Item No. Report of the Head of Planning and Enforcement**Address** 27 LAWRENCE ROAD HAYES**Development:** Single storey rear extension**LBH Ref Nos:** 40786/APP/2017/779

Householder consent is sought for a single storey rear extension.

PROPOSED

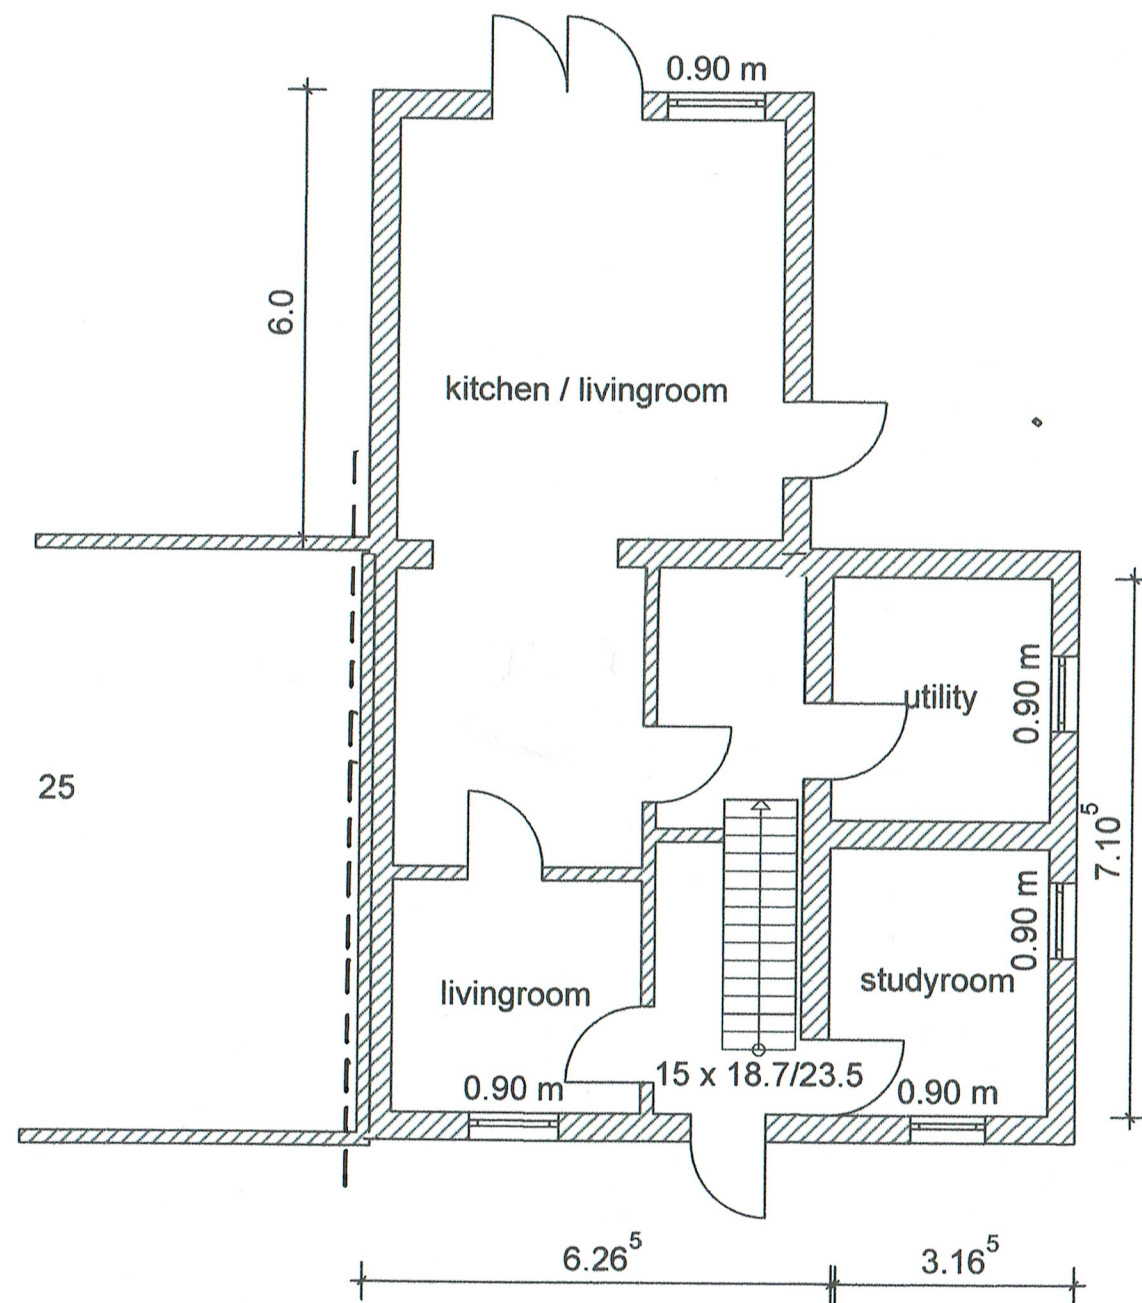
The proposed single storey rear extension would measure 6.0 m deep, would extend the full width of the original rear wall and would be characterised with a 2.9 m high flat roof. The extension, although of a depth which exceeds the recommended limitations outlined within the SPD, would comprise of a single storey composition, would have a low level flat roof, and would retain sufficient space from the side and rear boundary to avoid appearing cramped, and given it would project beyond the rear wall would satisfactorily integrate with the appearance of the host dwelling and the visual amenities of the street scene and surrounding area.

No. 25 which forms the other half of the semi-detached pair does not benefit from any form of rear addition, as such it is considered a single storey rear extension projecting 6 m beyond the original rear wall and along the shared boundary would result in an overbearing, overshadowing and visually intrusive addition when viewed from their rear aspects and, given the orientation, as such would result in a loss of their current daylight, sunlight and outlook levels currently enjoyed.

The single storey rear extension, by reason of its size, scale and siting is considered to be an overbearing structure that would overshadow the adjoining property at No. 25 which forms the other half of the semi-detached pair resulting in a loss of their residential amenities and light levels and would therefore be contrary to Policies BE19, BE20 and BE21 of the Hillingdon Local Plan Part Two: Saved UDP Policies (November 2012).

The single storey rear extension, by virtue of its size, scale, bulk, depth and proximity, would be detrimental to the amenities of the adjoining occupiers at 25 Lawrence Road, by reason of over-dominance, overshadowing, visual intrusion, loss of light and loss of outlook. Therefore the proposal would be contrary to policies BE19, BE20 and BE21 of the Hillingdon Local Plan: Part Two - Saved UDP Policies (November 2012) and the Council's adopted Supplementary Planning Document HDAS: Residential Extensions.
